**Re: Canterbury Bankstown City Council Submission to the Response to
Submissions State Significant Development Application, SSD-97092958 –
(redevelopment of the former WSU Milperra campus)**

Thank you for the opportunity to provide a submission in response to the exhibition of the Response to Submissions for the State Significant Development (SSD) Application SSD-97092958 at 2 and 2A Bullecourt Avenue, Milperra. Council has reviewed the documentation made available on the Department of Planning, Housing and Infrastructure (the Department) website and enclosed with this letter is Council's response.

Figure 3.3: Proposed Site Access - Ashford Avenue

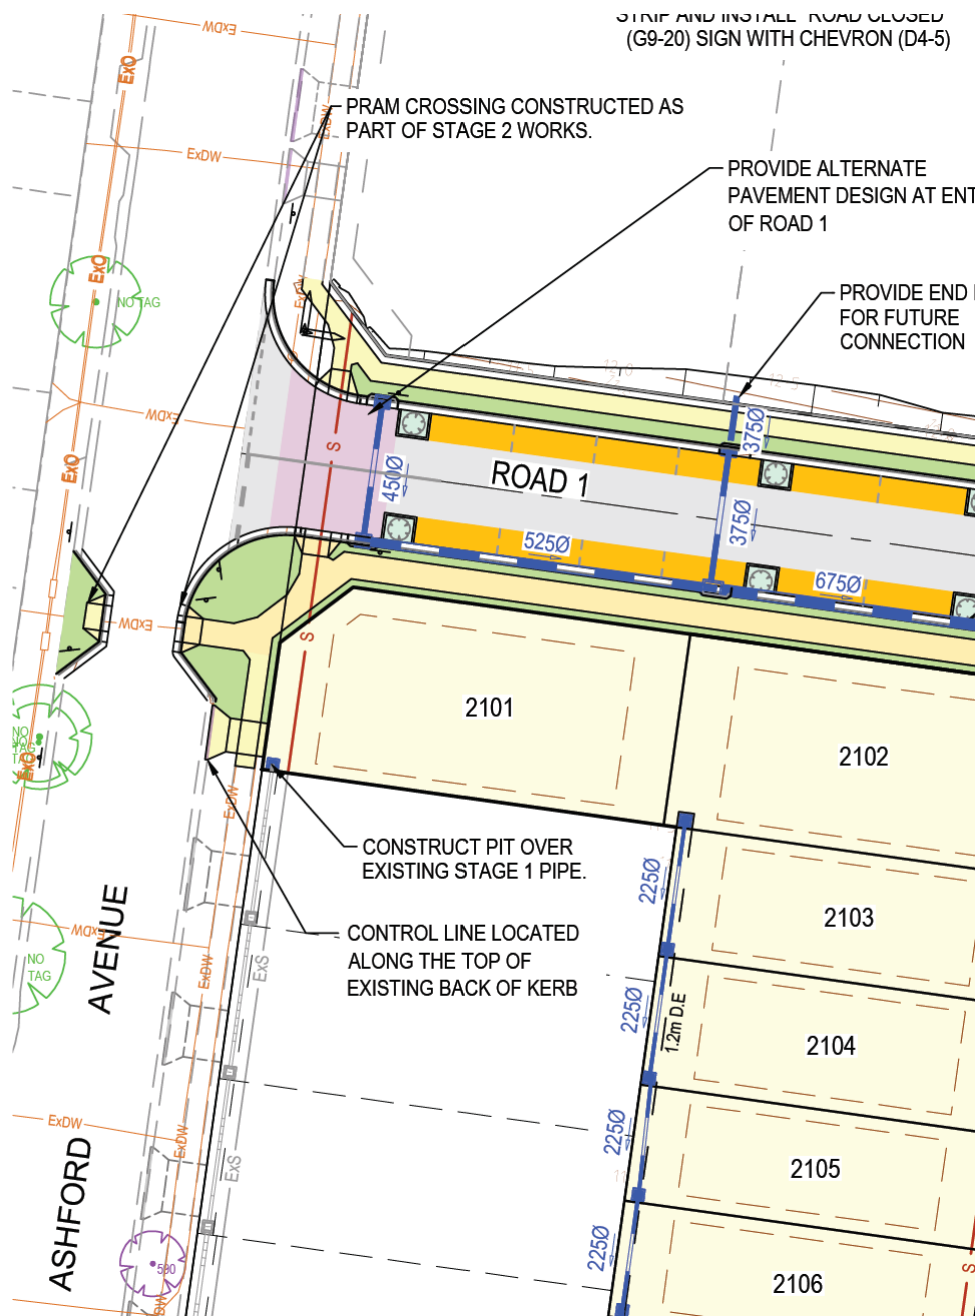
Traffic	1. Raised pedestrian crossings One speed hump along the shared boundary o Nos 148 and 150, a slow point with kerb blisters at the shared boundary of Nos 152A and 154-166 Ashford Ave and raised crossing towards Flanders Ave is being proposed. Council supports the provision of a raised pedestrian crossing in the vicinity of Pedestrian Link 1, as this location aligns with an anticipated pedestrian desire line generated by the development. However, the detailed design of the raised pedestrian crossing must take into consideration existing drainage conditions and include appropriate stormwater management measures to ensure that surface water flows are maintained and that no adverse drainage impacts result from the installation of the raised crossing and kerb extensions. Council supports these revisions in principle, subject to detailed engineering design submitted to our Design team for review and drawings showing proposed traffic calming measures with signs and lines to present at a forthcoming Local Traffic Forum prior to installation. These devices are acceptable. 2. Swept paths at the slow point Provided and acceptable. 3. Proposed changes to the roundabout access on Horsley Road Council acknowledges that the Applicant has addressed Council's previous comments relating to the Horsley Road access arrangements. Specifically, the

Figure 3.4: Proposed Site Access - Horsley Road

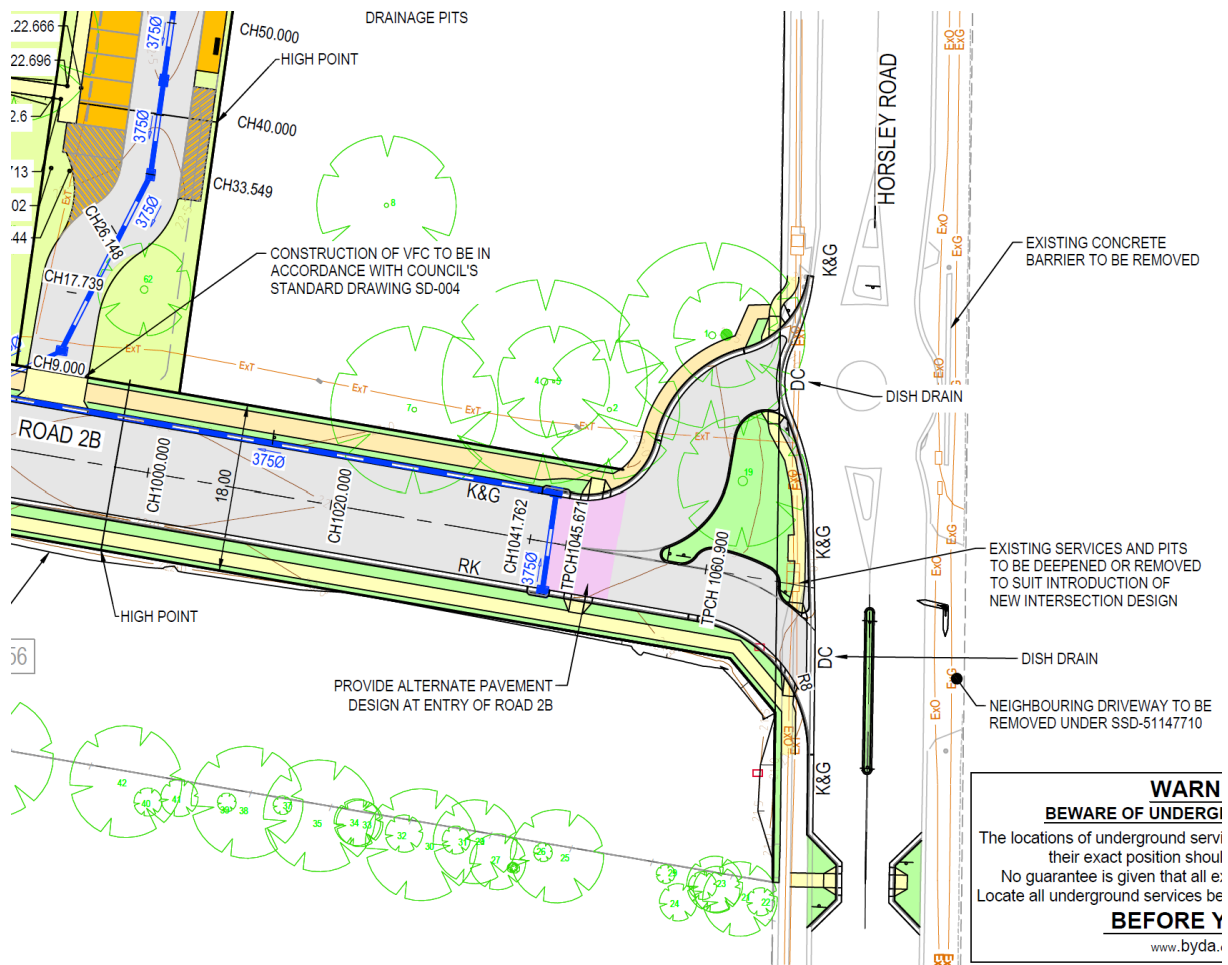
Category	Council Feedback
	revised design incorporates the extension of the raised median island to reinforce the prohibition of right-turn movements into the access road, reconstruction of the existing splitter island to achieve compliance with current pedestrian refuge standards, and the provision of a slow point with kerb blisters to facilitate safer pedestrian crossing movements over a reduced carriageway width. Council supports these revisions in principle, subject to detailed engineering design submitted to our Design team for review and drawings showing proposed traffic calming measures with signs and lines to present at a forthcoming Local Traffic Forum prior to installation.
Development Engineer	The following points need to be addressed by the applicant prior to any determination being issued by the Department: All Stages: Operation and Maintenance Manual shall be prepared relating to the maintenance of the proposed drainage infrastructure and water quality treatment devices. Detention and bio-retention basins (currently not in the list in the WSU Milperra – DA Engineering Design Report) need to be included. The applicant must review and liaise with Council's Road Operations team regarding this requirement. Pre and post-construction CCTV of existing and proposed pipes shall be submitted to Council to ensure there are no damages and no protruding pipe inside Council's pipes All existing services shall be coordinated with relevant authorities for removal, relocation & proposal Multiple VFCs frontage shall be constructed in accordance with Council Standard Drawing S-004, S-007 and S-008. The following requirements shall be adhered to at a minimum: i. Minimum 5.5m on-street parking space shall be provided along each site frontage. ii. Minimum 1.0m offset between VFCs and side property boundaries. iii. Minimum 2.0m clearance from VFCs to street trees. iv. Minimum 0.6m clearance from VFCs to green supply electricity boxes and street lighting poles. v. Minimum 0.5m clearance from VFC wings to Council lintel pits. Note: Concurrence from TfNSW for the sediment basin storage volume and discharge is required as it is their drainage infrastructure and assets that will ultimately be affected by this (i.e. it is not discharging onto any Council owned drainage infrastructure). Stage 1: • Existing power poles along Ashford Avenue shall be shown on the engineering plans and any impacted by proposed VFCs shall be relocated
